MMC Site Plan Check In meeting 3/1/2018

Key points from the **3/1/18** Site Plan Review meeting with MMC:

**EAST TOWER STRUCTURAL STEEL  
TRUCK DEPARTURE ROUTE FROM WESCOTT SITE  
WESCOTT ST TO CHARLES ST TO BRAMHALL ST TO DEERING  
AVE TO PARK ST TO I295**

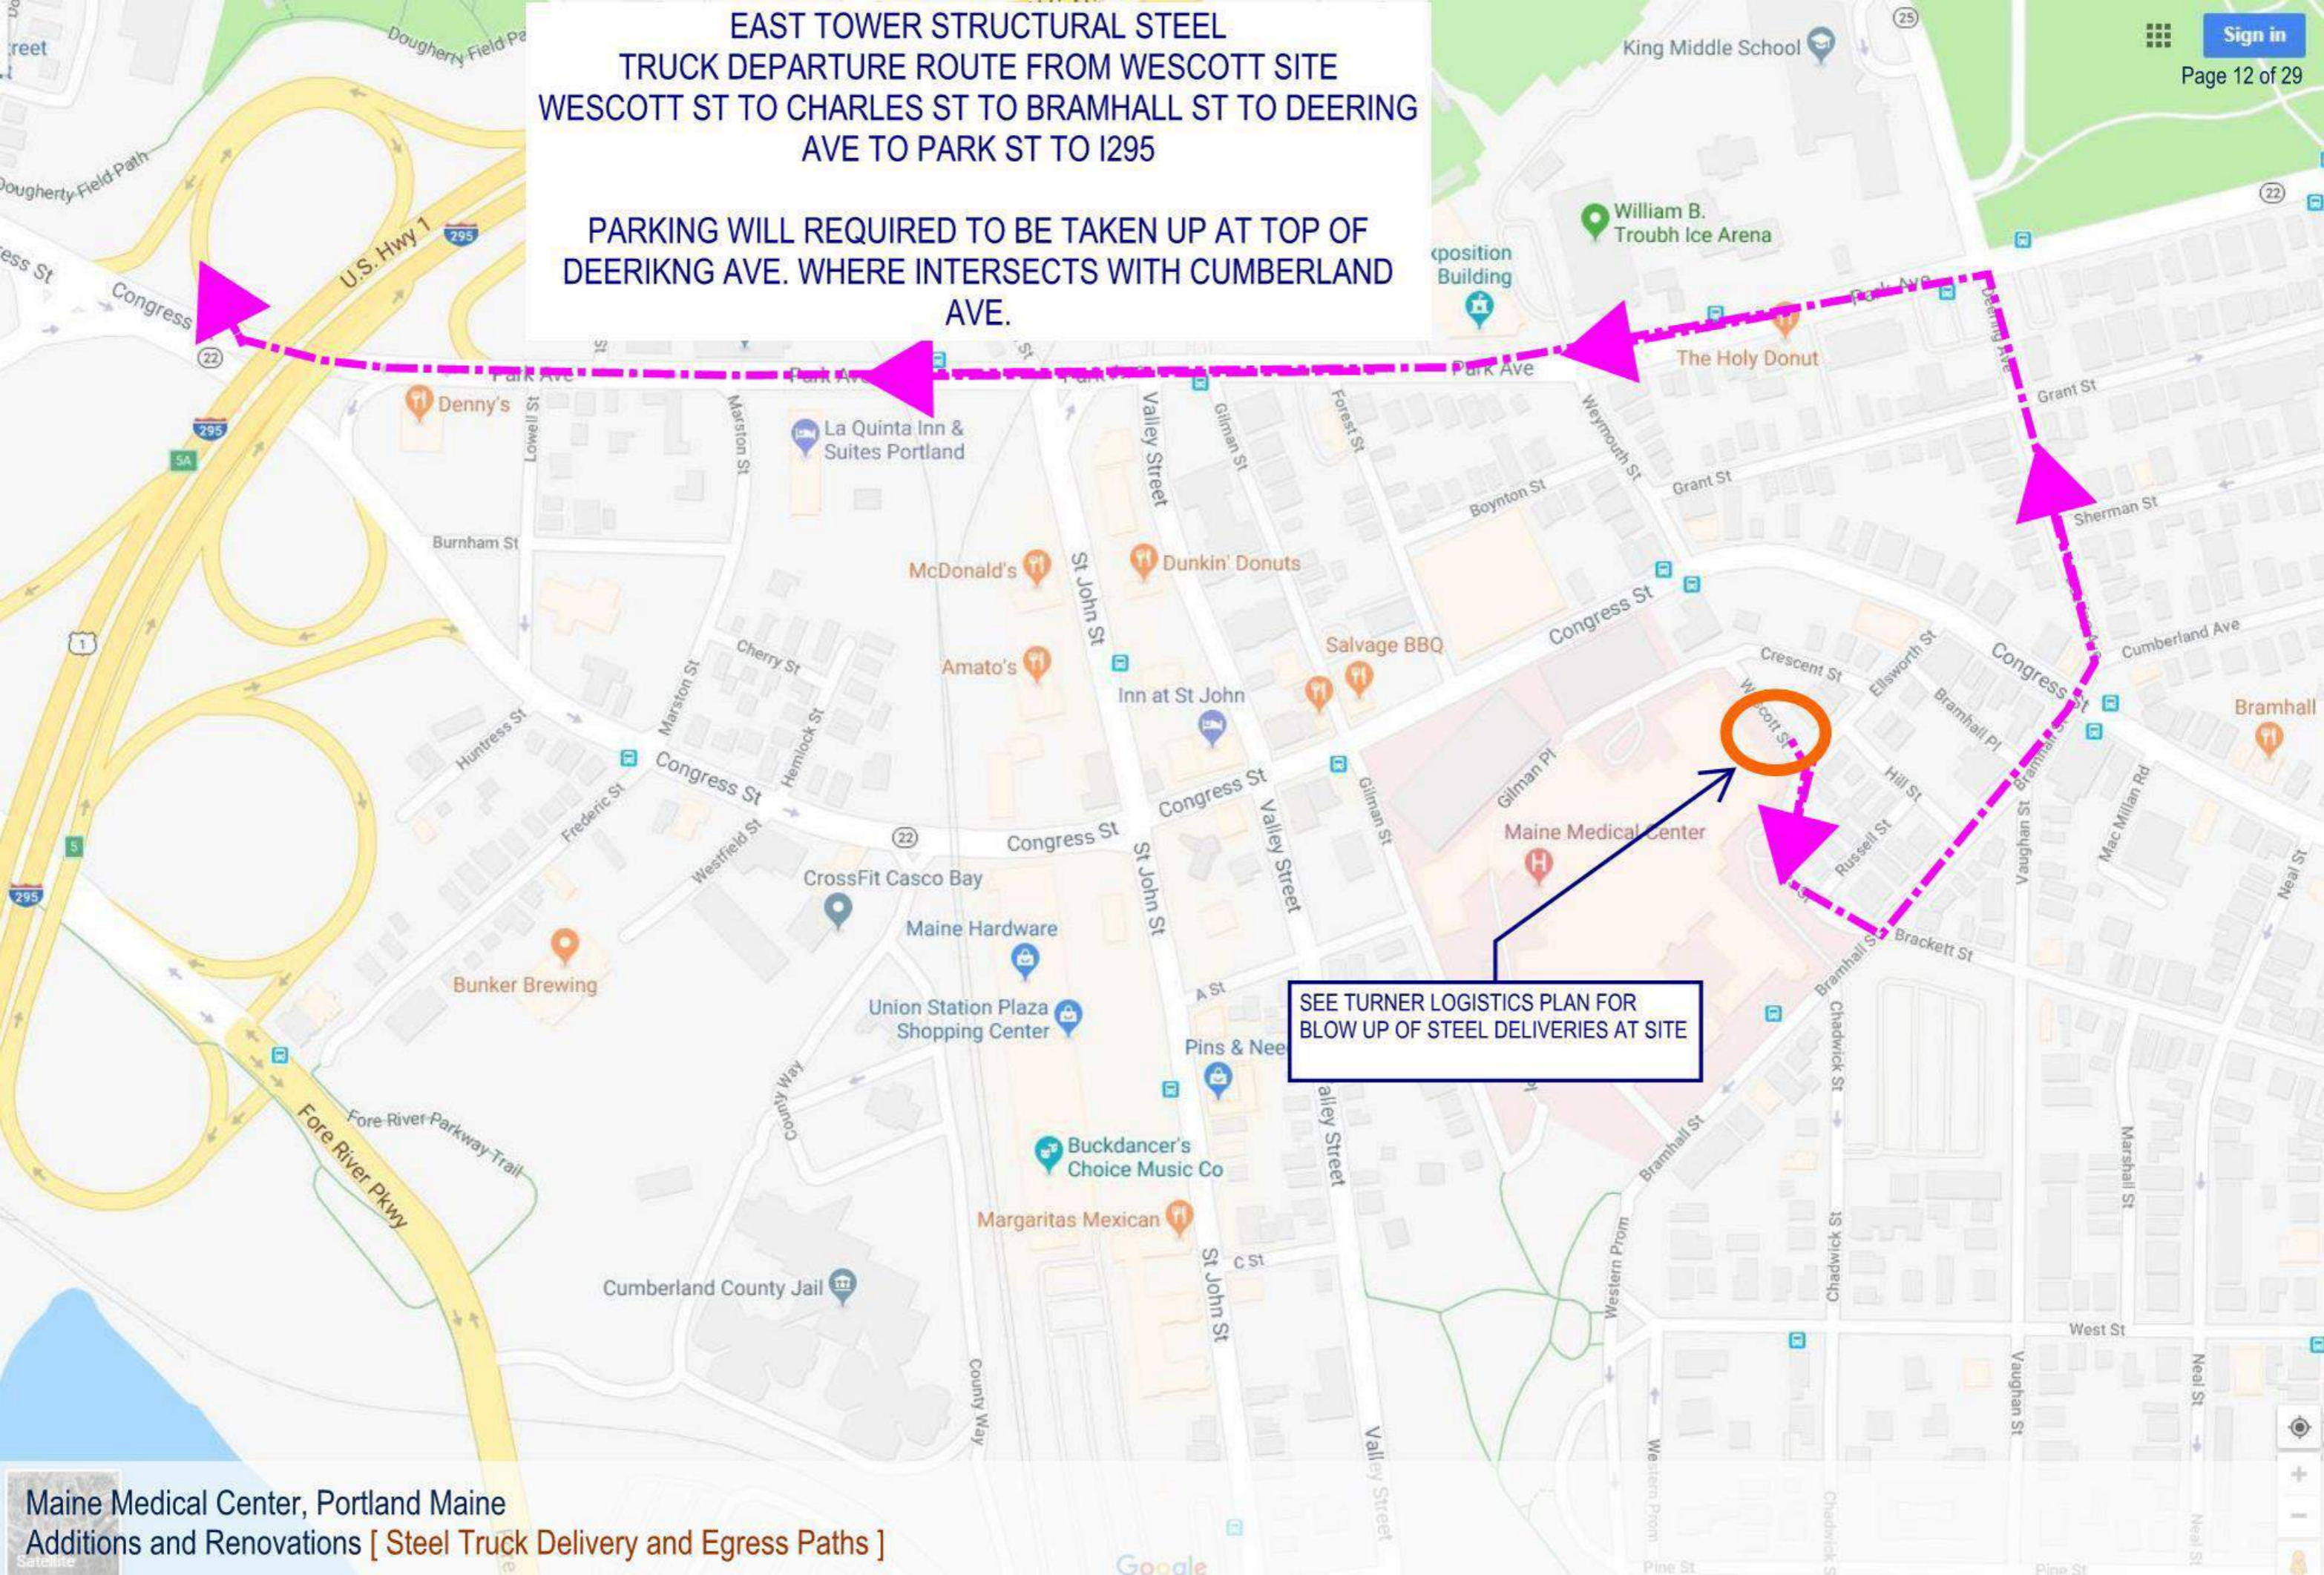
- At the 2/15 meeting reviewers questioned the proposal to route steel deliveries (from North, June 4 to June 28, starting at 5am; 3-4 /day) along Washington Ave and Congress
 - City staff advised route should avoid Washington completely due to planned construction work
 - Route must avoid downtown Portland and Congress
 - Keep delivery vehicles on I295 longer - maybe I295 to Forest /Park ? Deering; maybe Fore River Parkway
 - Turners were going to speak to the trucking company again and get back to us
- Turners had discussed further with trucking company
 - Looked at a number of alternatives
 - Those at the meeting preferred the incoming route to be High to Congress to Ellsworth
 - Those at the meeting basically OK with exit route (Bramhall to Deering to Park) but may need tweaking re turn onto Park
